RESPONSE TO PLANNING COMMENTS INCLUDING CALCULATIONS – Rev. F

SIMPLY UK

HOOK ROAD, PAGHAM

CS&P REF: 9418

DRAINAGE LAYOUT

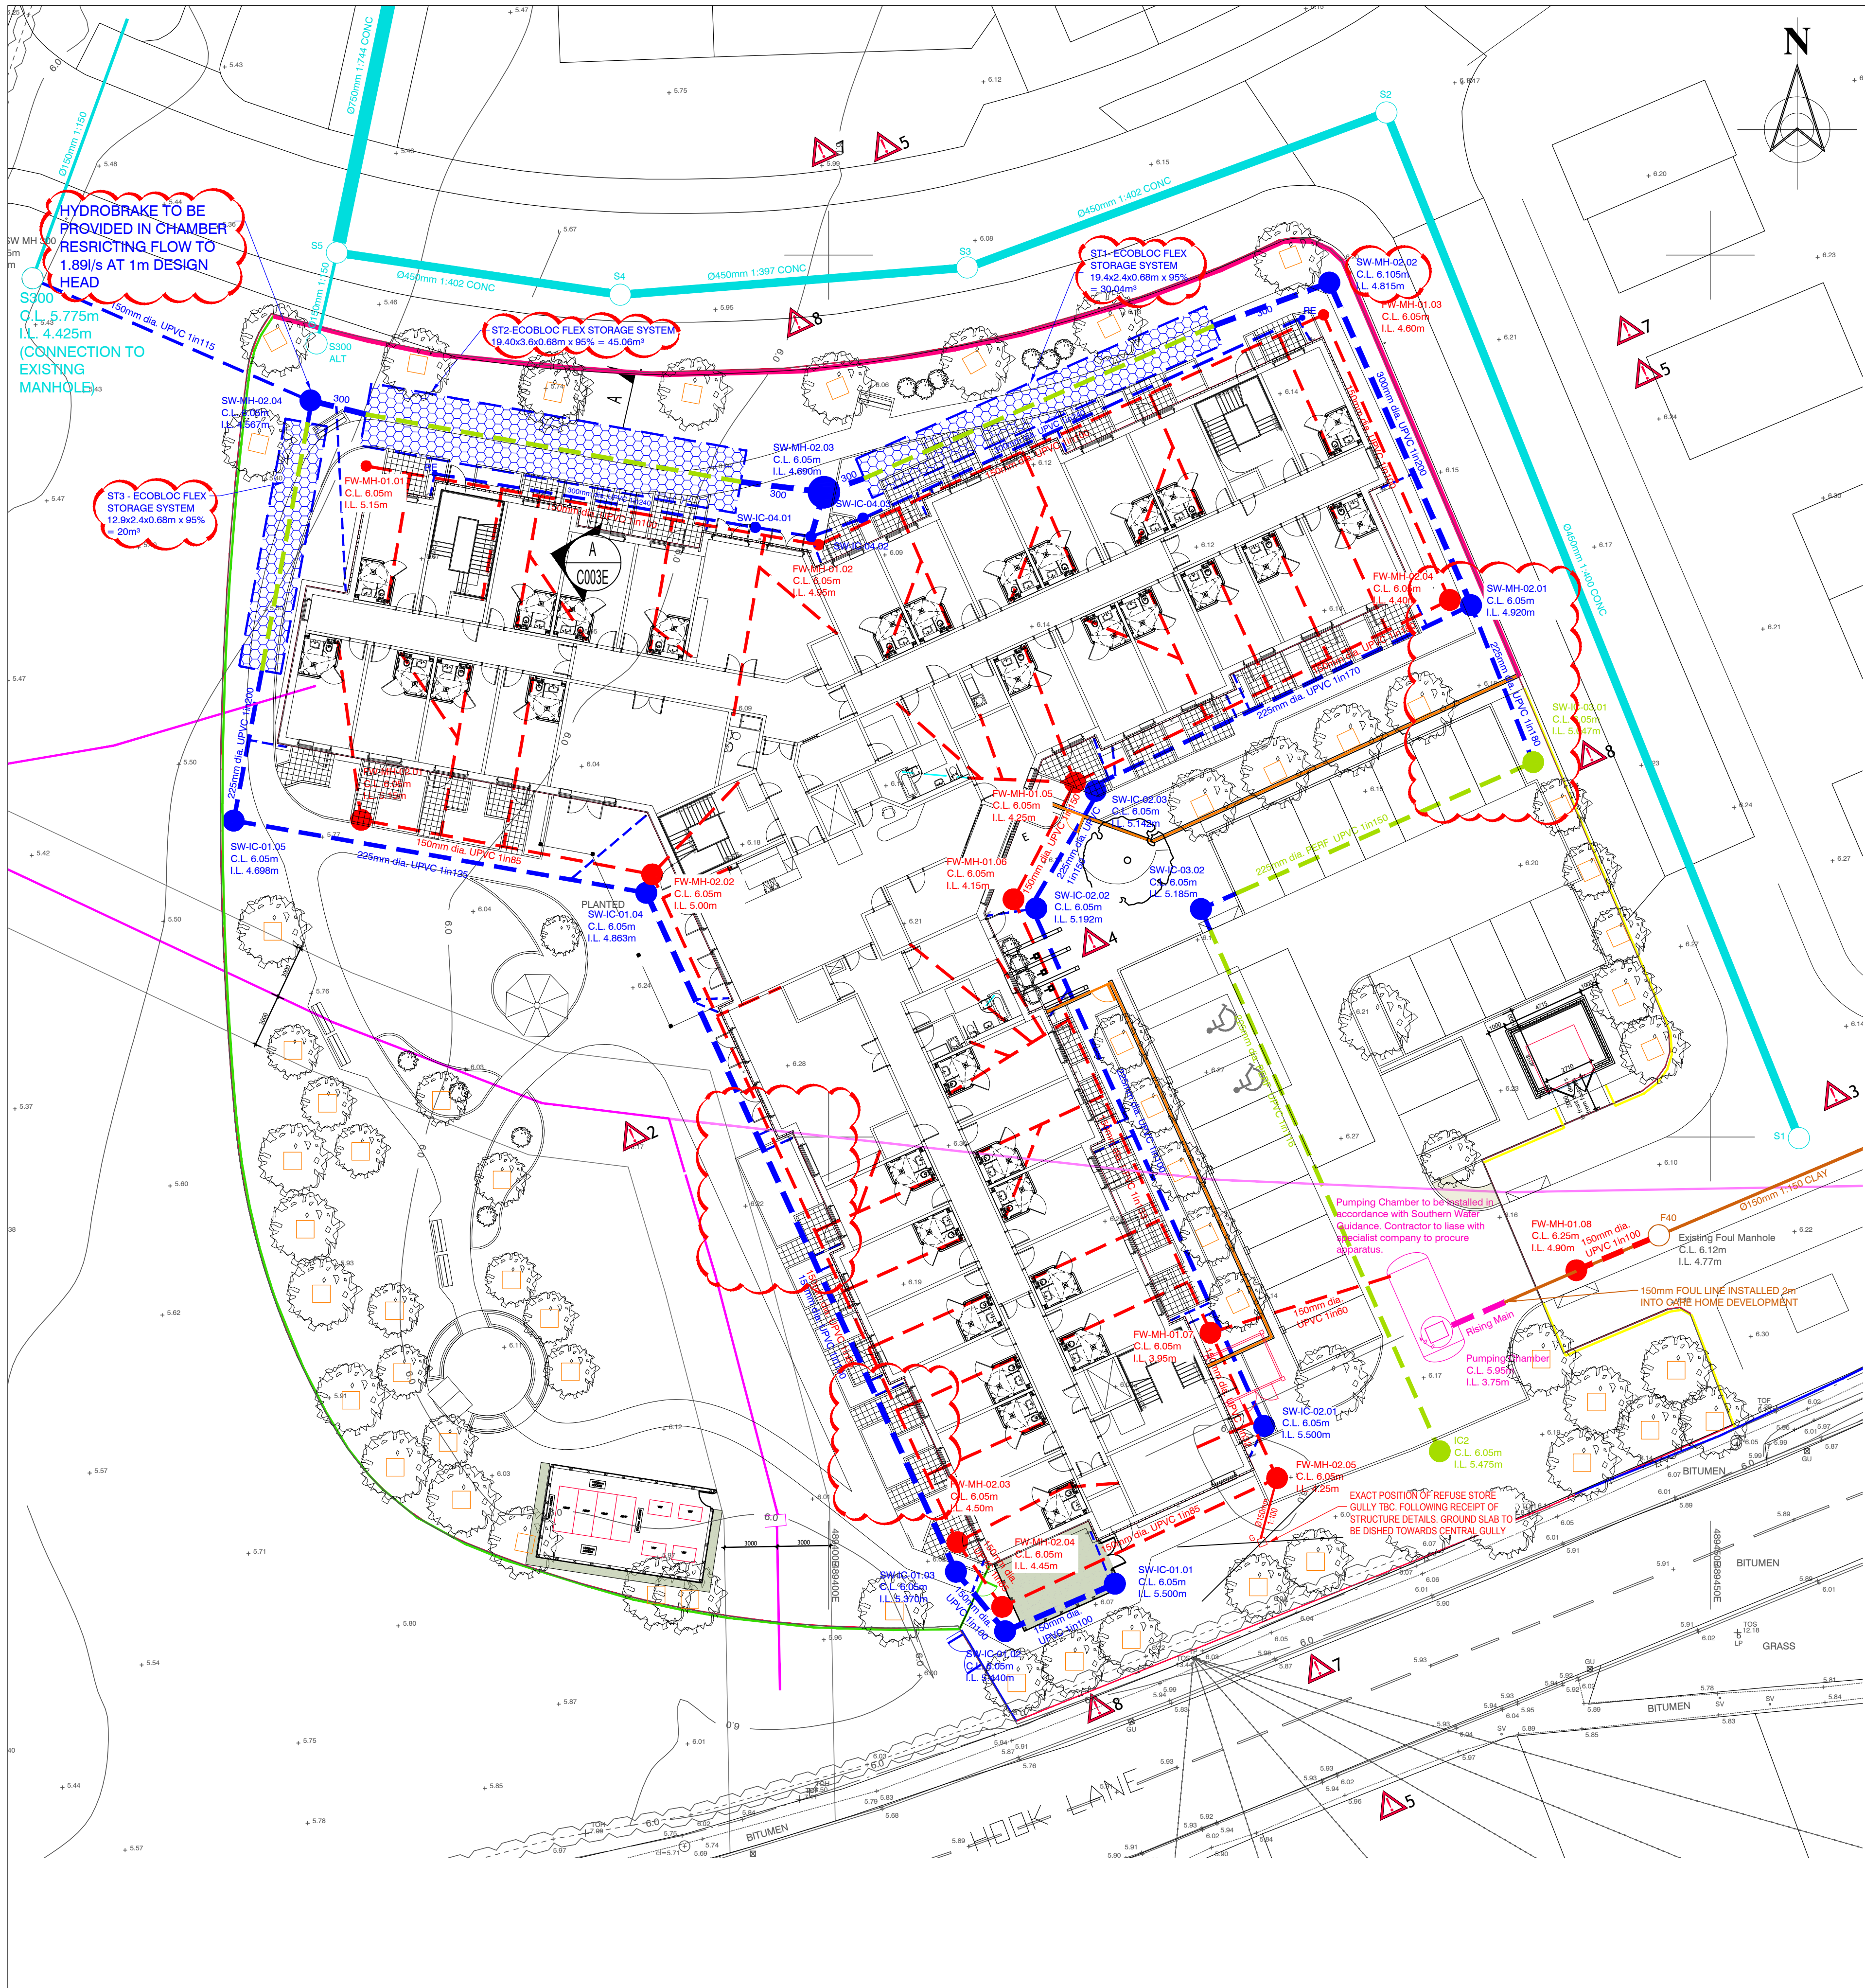
The calculations in Appendix B dated 07/11/2025 still appear indicate 2l/s outflow at outfall MH02.05 for the M100 +45% event. Please review and resubmit accordingly.

The previous revision B calculations were modelled on a 1.9 l/s discharge. The Causeway flow drainage design software does not allow a 1.89 l/s discharge. The figure is rounded up to 1.9 l/s. We have asked the drainage support to check this and this can not be rounded down to 1.89 l/s unfortunately.

As such – we have modelled the drainage calculations on a 1.8 l/s discharge rate. See attached screenshot.

We have revised the calculations and the drawing to reflect the 1.8 l/s discharge. This shows that the surface water network is sufficient to accommodate this slight increase in flow. Trust this answers this point. See Appendix B for details of the Causeway support email and revised calculations.
